**CITY OF ALBUQUERQUE
PLANNING DEPARTMENT
January 27, 2016
DRB Comments**

PROJECT # 1010537

APPLICATION # 16-70016

RE: Lots A-1 and A-2, White City and Glenhaven Addn

**PLAT OF
TRACT A-1-A AND A-2-A
WHITE CITY - GLENHAVEN ADDITION**

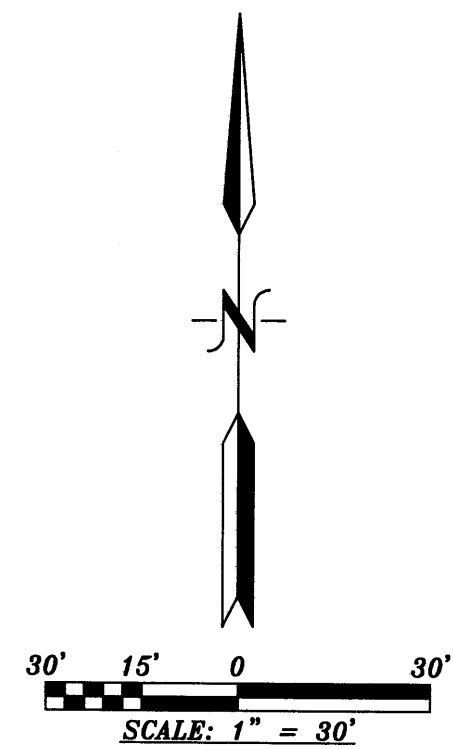
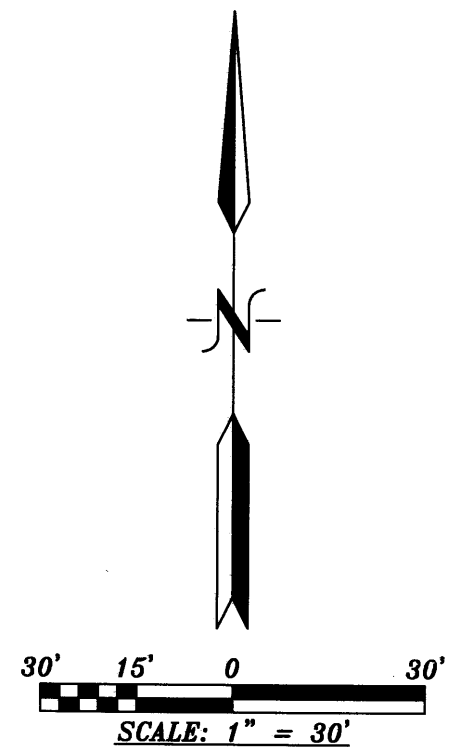
Property lines need to be shown on the Site Sketch, and it appears some measurements on the plat drawing need to be corrected. Right of way dedication is needed for 4th Street and Phoenix Avenue to include public sidewalks and setback areas – refer to comments from Transportation Development. Compliance with Building Code for zero lot line on new 4th Street right of way may be needed.

Existing Lot A-2 is a distinct site zoned P; the 'Old Lot Line' needs to be memorialized on the plat as a Zone Boundary.

SITE PLAN

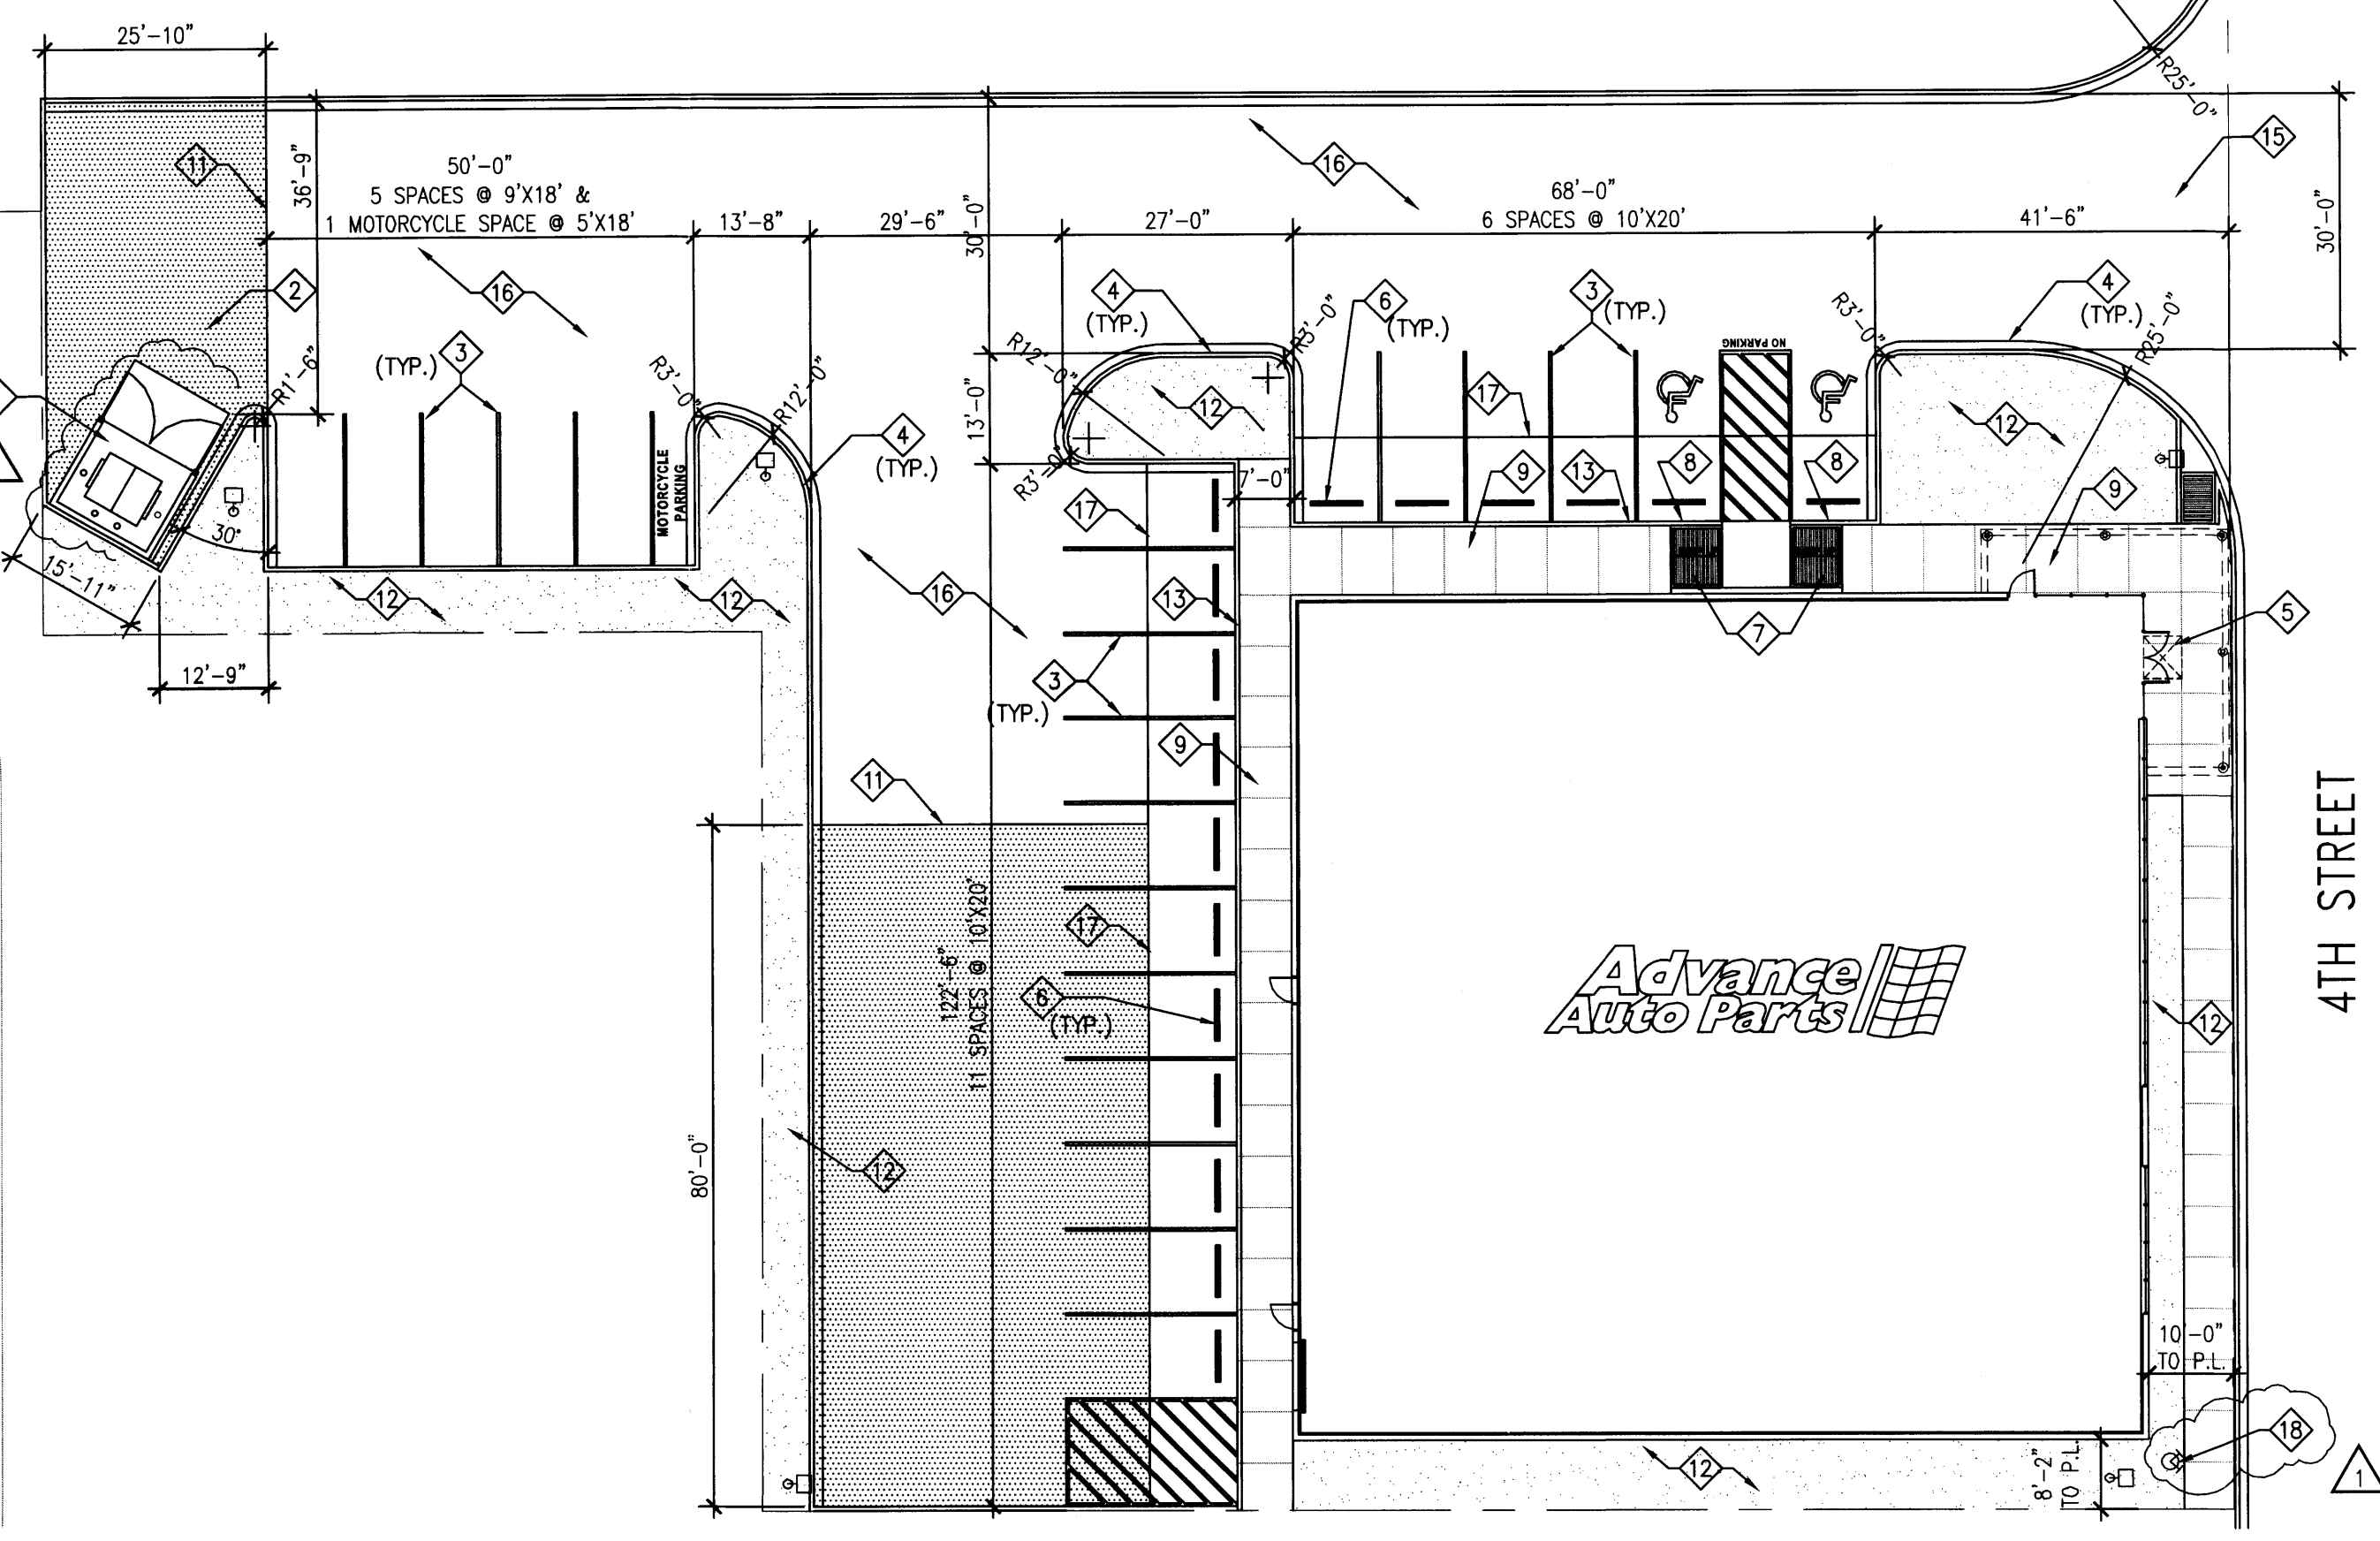
An Infrastructure List/ sidewalk will be needed for 5th Street frontage.
